**Consultation Response from Alan Smith,
KC Waste Strategy (Refuse & Recycling)**

2025/91639 40, Bradford Road, Fartown, Huddersfield, HD1 6JE

Erection of 3 storey extension and alterations to form student accommodation

Date Responded: 23/07/2025

Drawing Title:
PROPOSED FLOORS PLANS

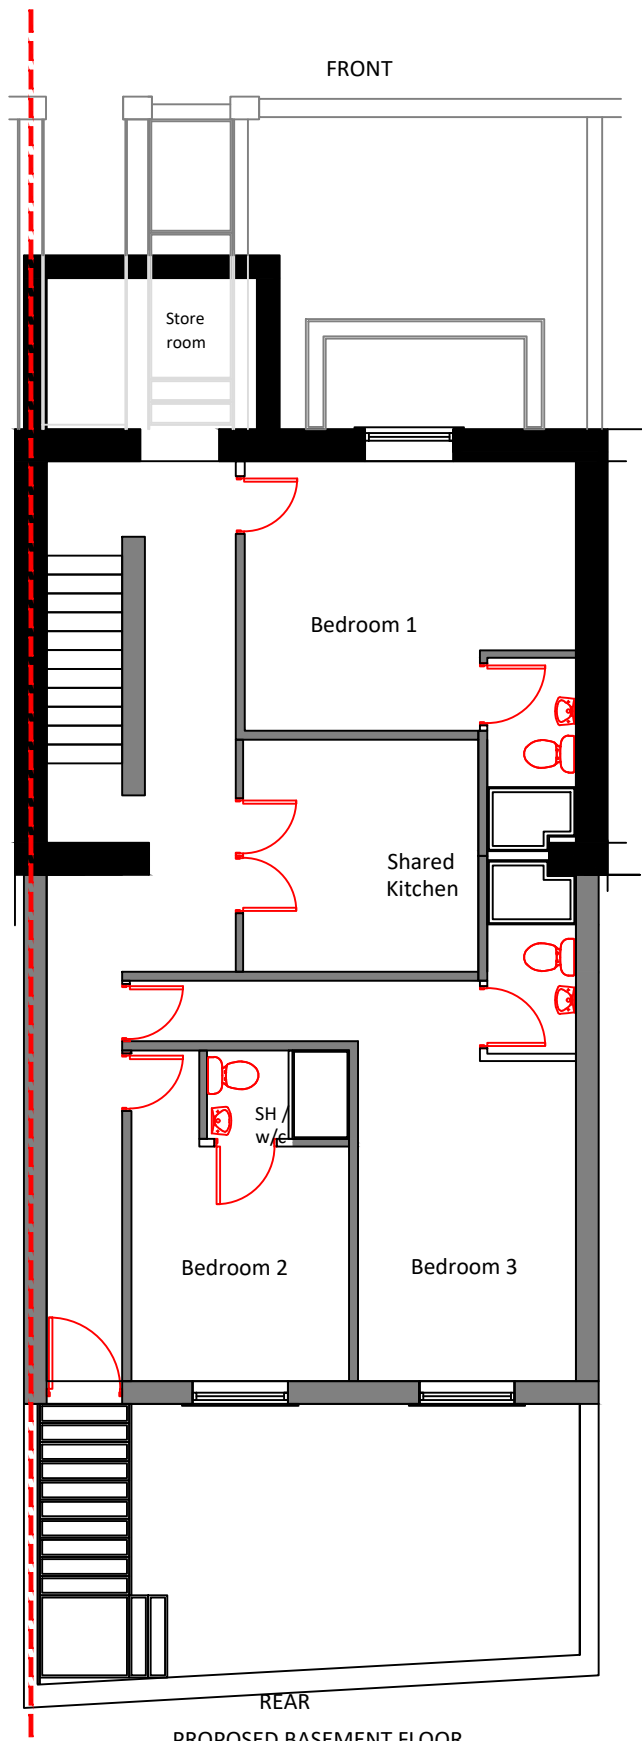
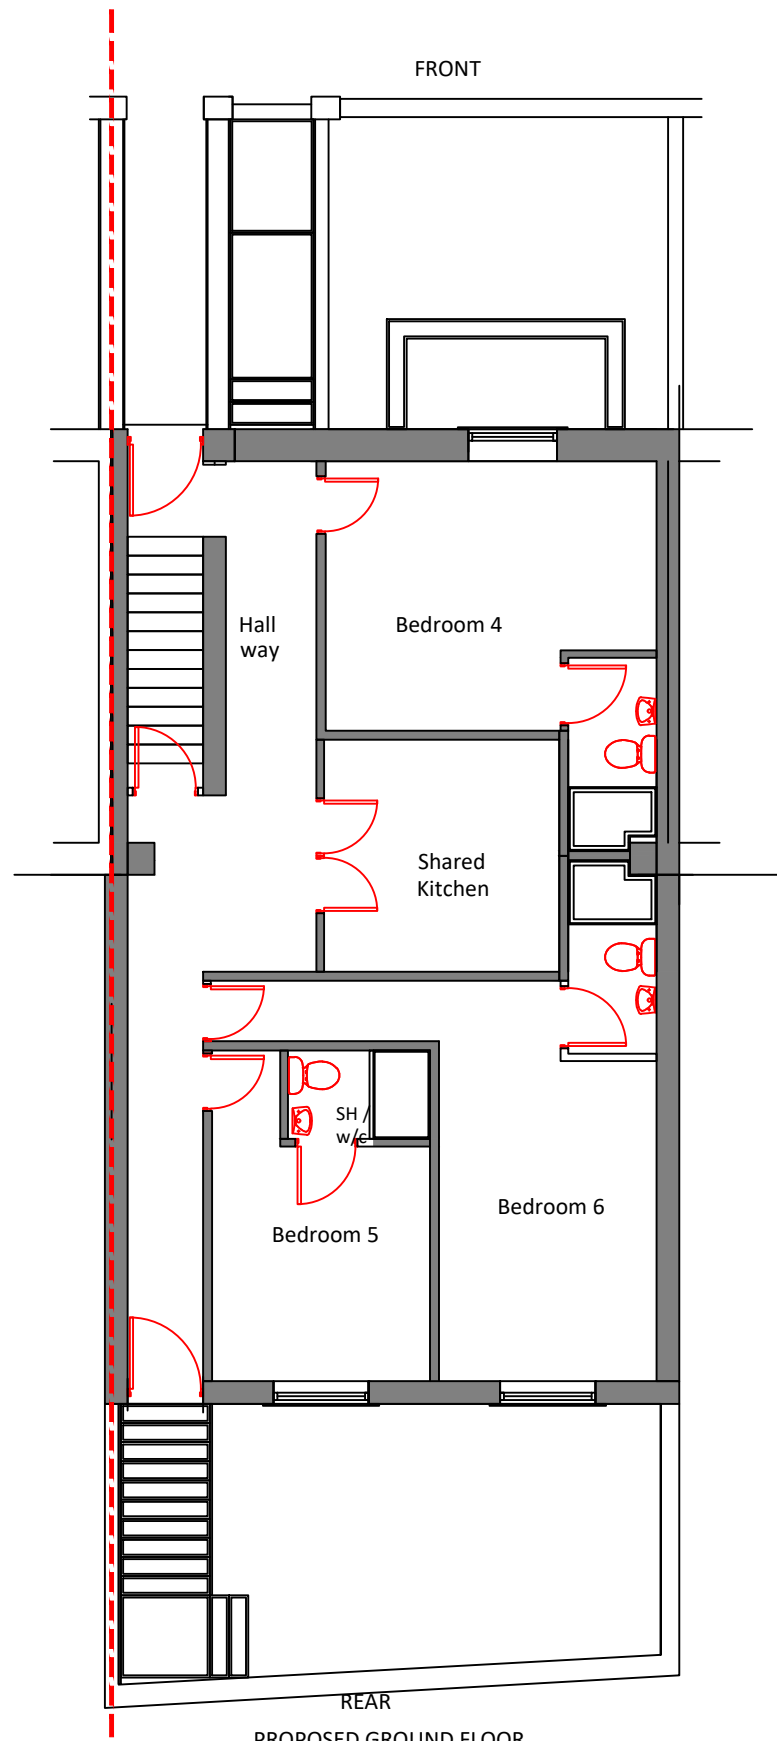
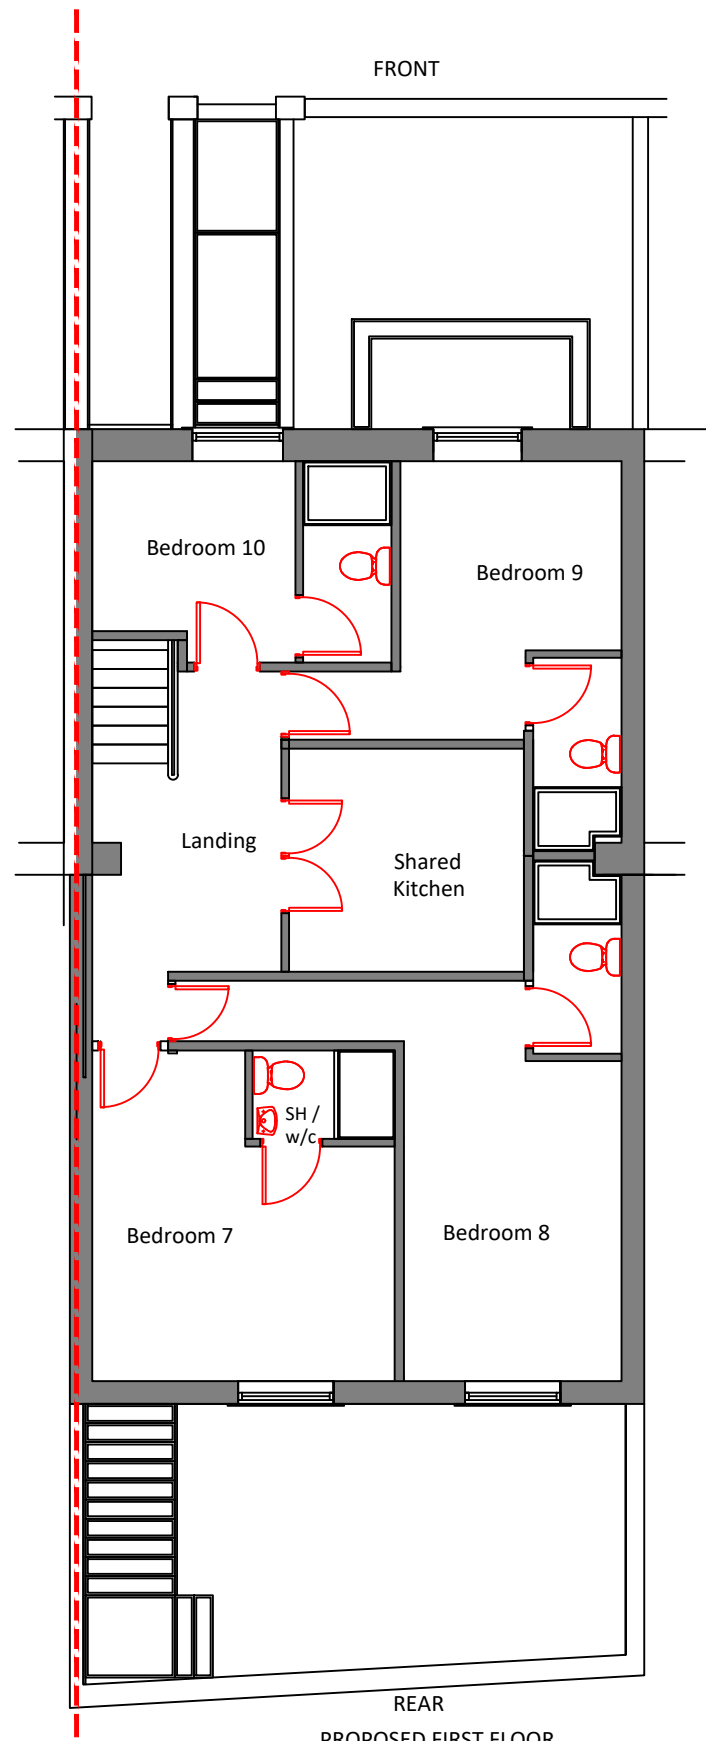
- The application is for the construction of 10 apartments. As the proposal is for a House in Multiple Occupation the development is entitled to 2 x grey 240ltr bins and 1 x green 240ltr bin. The green bin is only for recyclable material. It is not clear from the plan where these bins are going to be stored on the property. The WCA would like further details of where it is proposed the bins will be stored.

- The bins will need to be placed in a bin store which should be of suitable dimensions to accommodate the required bins and constructed in compliance with the details specified in the design guide. The wheeled bin storage area should be secured to prevent unauthorised use. It is important that there is adequate room to manoeuvre the bins through entrance to the property for collection on Bradford Road. Wherever these bins are stored they will need to be placed on the footpath on the day of collection and then returned to the property.

- Due to the bin storage area being potentially very close to the building the bin store must comply with fire regulations (refer to BS 5906:2005 Waste Management in Buildings; BS476-22:1987: Fire tests on building materials and structures; and BS EN 1634-1:2008: Fire resistance and smoke control tests for door, shutter and open-able window assemblies and elements of building hardware) for internal compounds.

- A. Before development commences, further details to ensure suitable storage, and access for collection of wastes shall be submitted to and approved in writing by the Local Planning Authority. The approved details shall be provided before first occupation and shall be so retained thereafter.
- B. Before development commences, details of the management and maintenance of communal refuse storage areas by a designated private management company shall be submitted to and approved by the Local Planning Authority. The approved details shall be provided before first occupation and shall be so retained thereafter.
